From: Simon Davis
Sent: 14 May 2019 15:35
To: John Carver [REDACTED]
Subject: RE: AL/45/18/PL GTR DENMANS LANE FONTWELL

Drag No RA/021/125 BLOCK PLAN

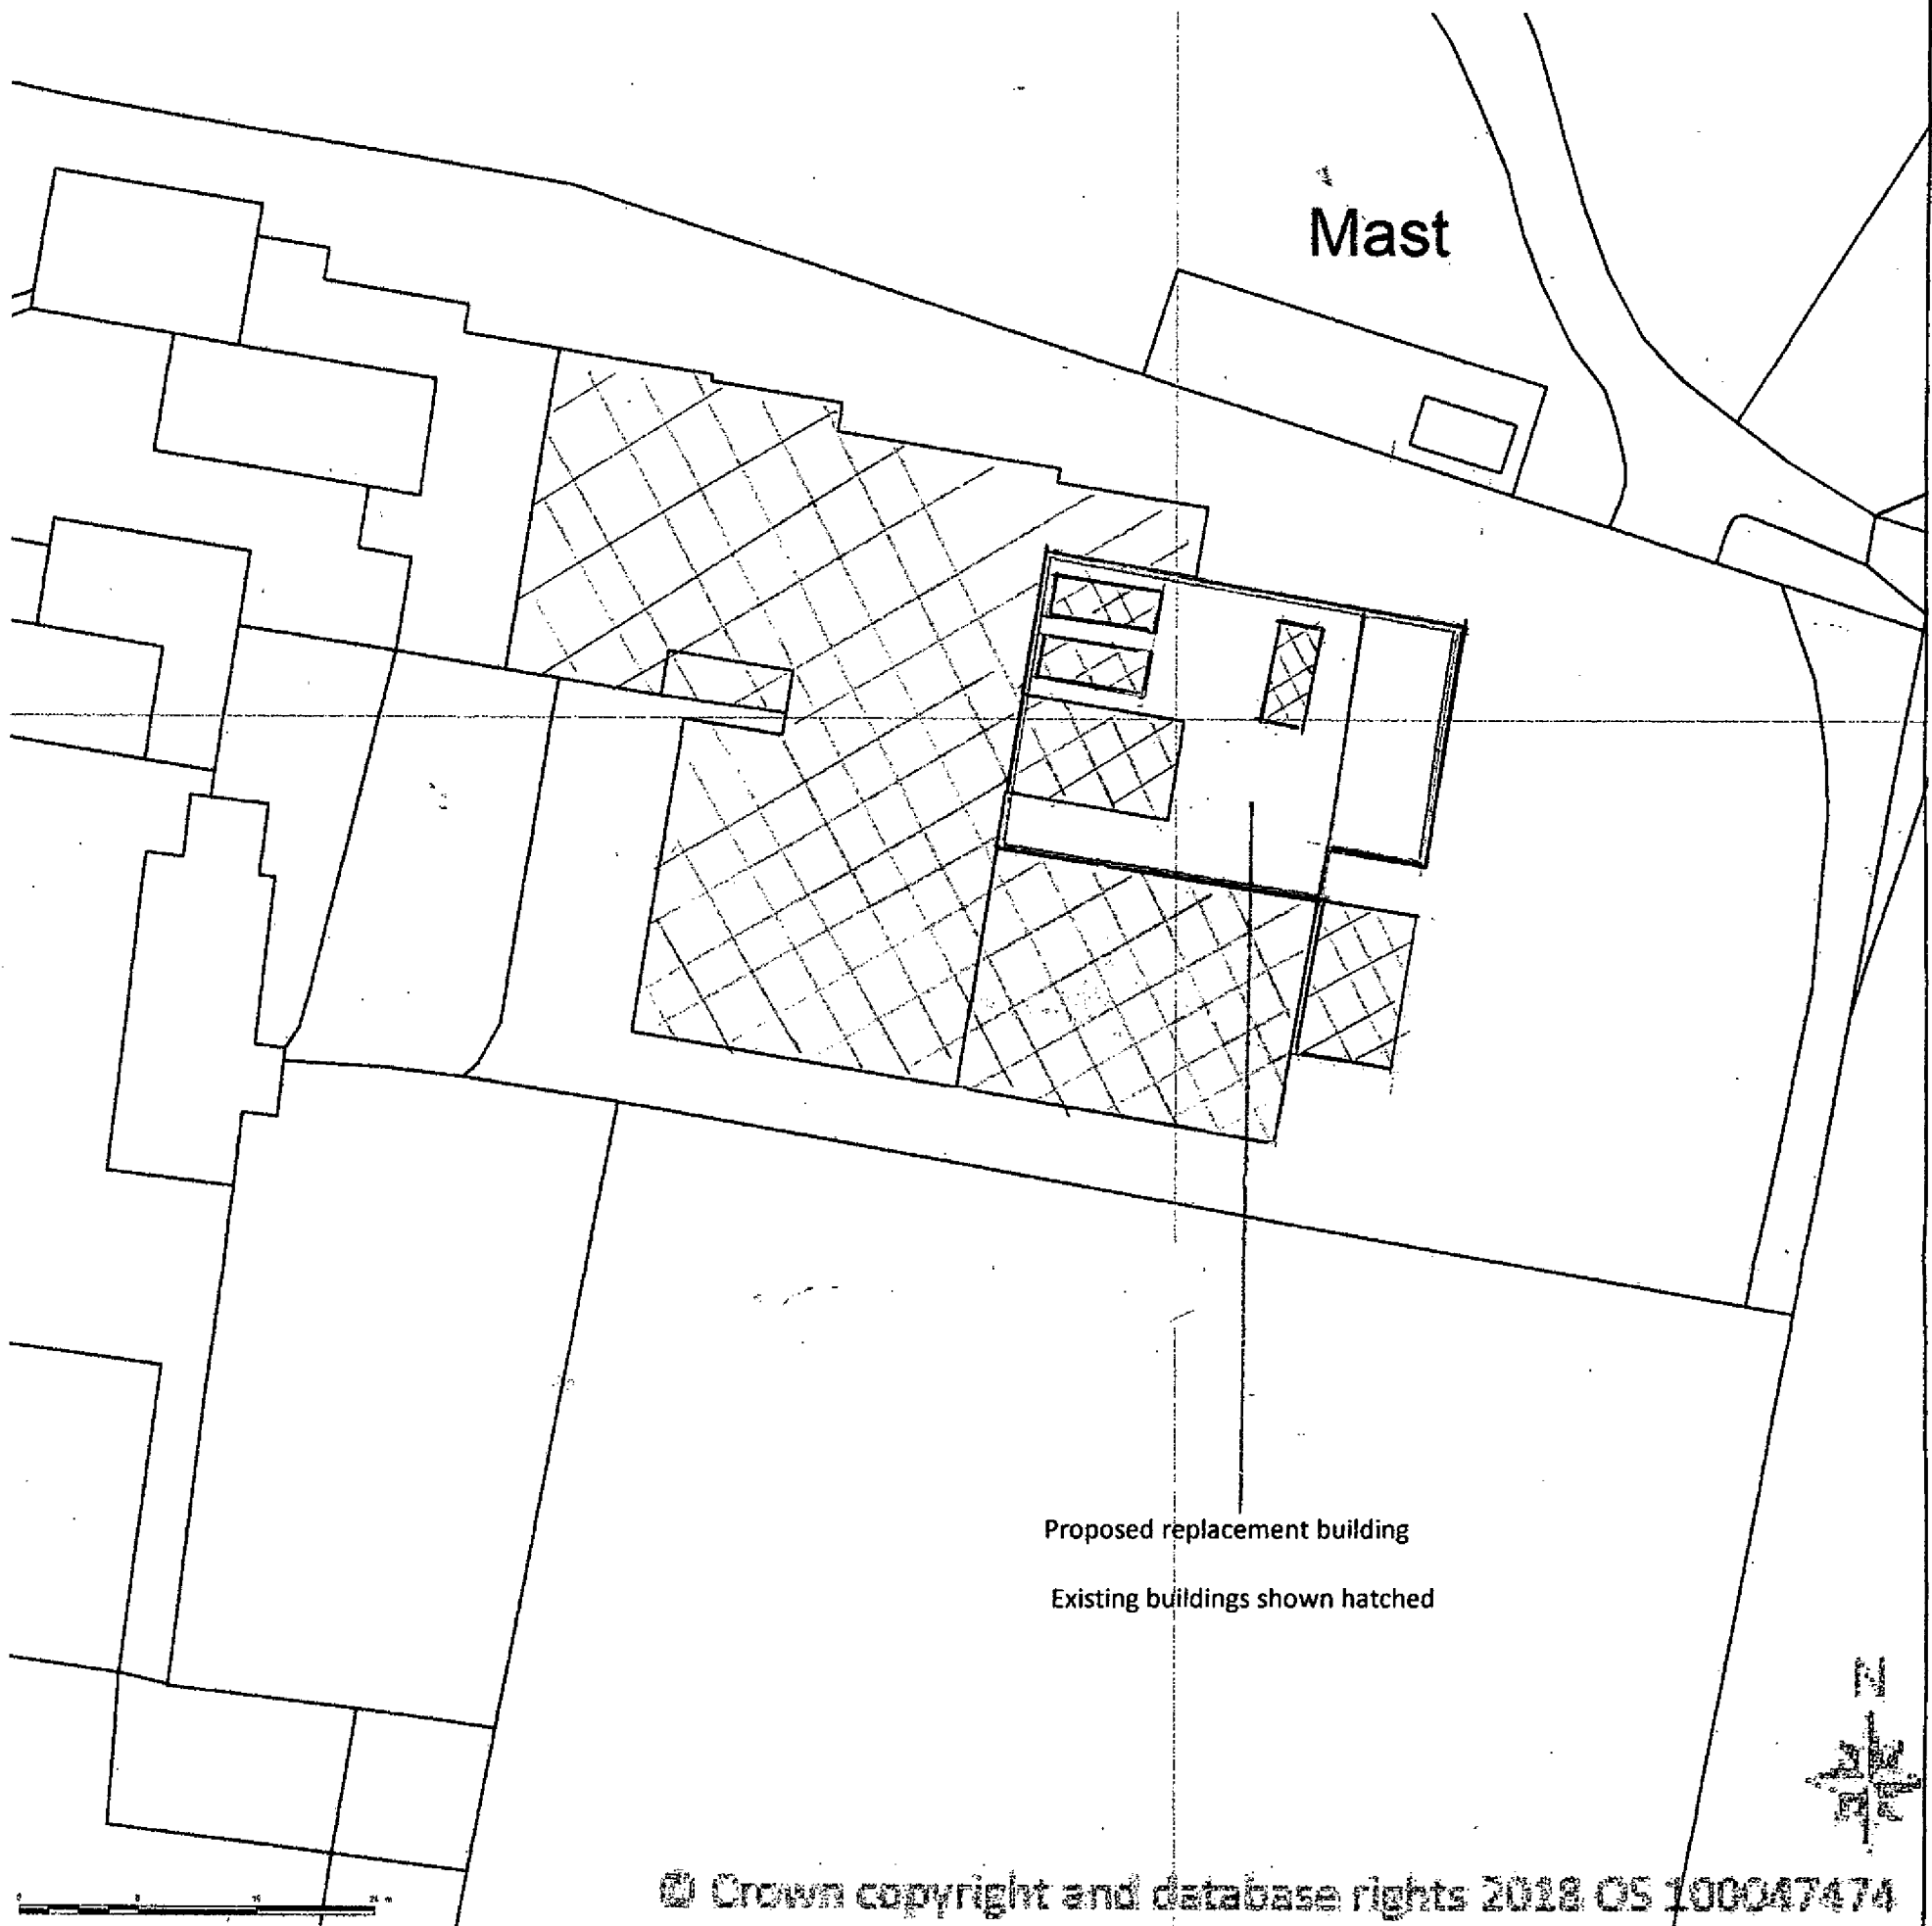
Thanks for these. However, the A3 portrait template block plan does not appear to show anything – can you check please.
